PLANNING APPLICATION CONSULTATION RESPONSE

Application Number:	3/2024/0451
Proposal:	Approval of details reserved by conditions 5 (SW drainage), 6 (Construction SW drainage plan) 10 (Construction Traffic Management Plan) and 13 (vehicular access) of planning permission 3/2023/0156.
Location:	Dog and Partridge Hesketh Lane Chipping PR3 2TH

Lead Local Flood Authority Position

Project: RESIDENTIAL REDEVELOPMENT
 THE DOGS & PARTRIDGE
 CHIPPING PRISTON
 DIVERSION OF SW DRAIN
 AND ABANDONMENT OF
 EXISTING FLYDRAINS

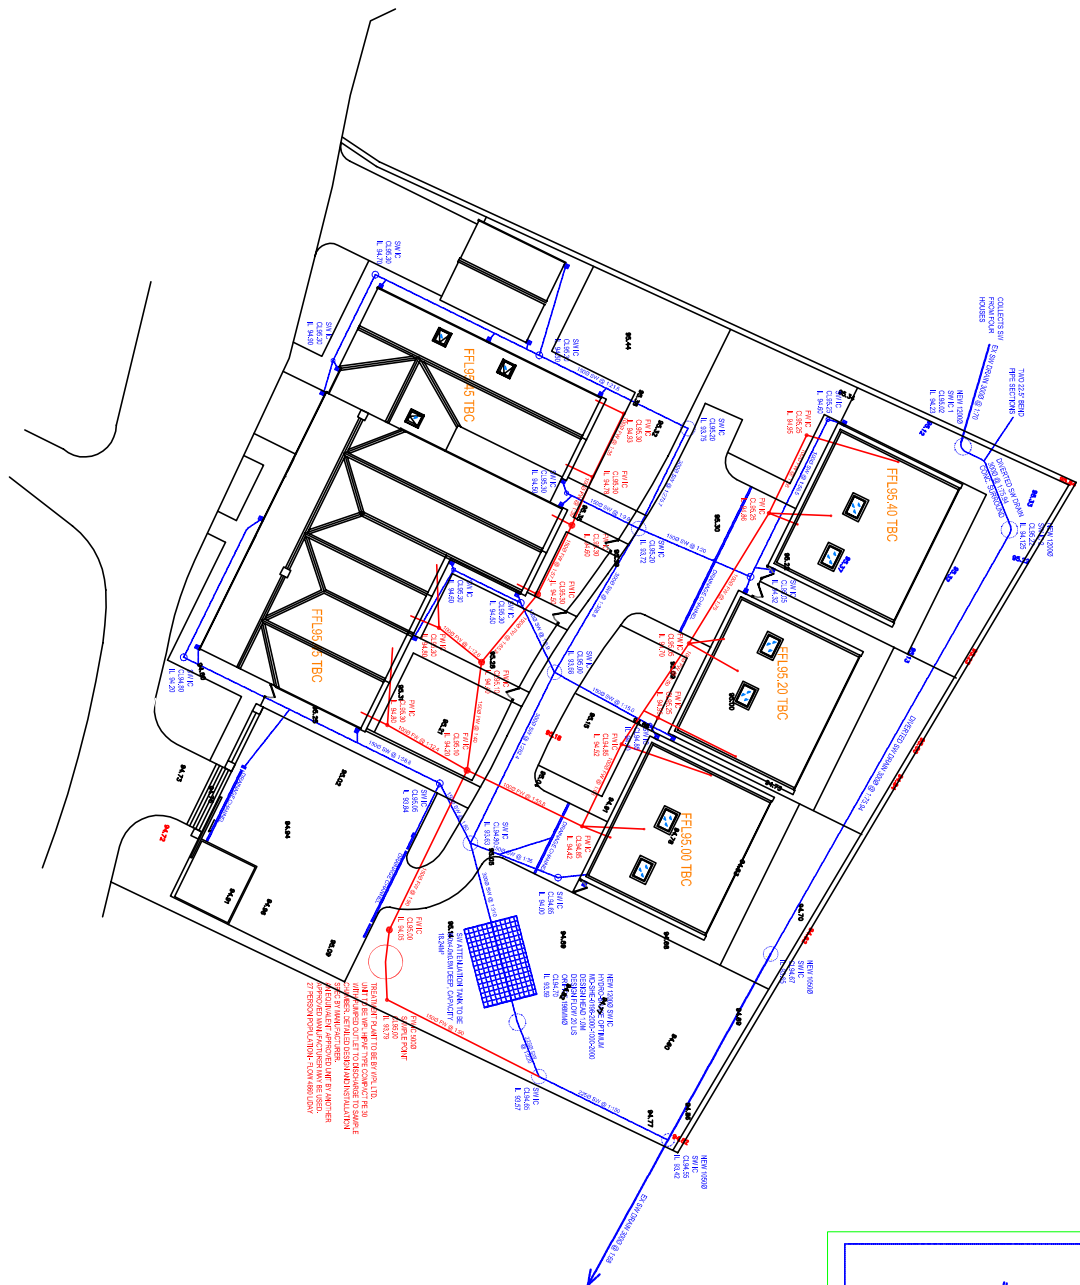
The Local Planning Authority should satisfy themselves that the proposed diversion of the surface water sewer can be suitably maintained and accessed given its proposed location within the rear properties of the new properties.
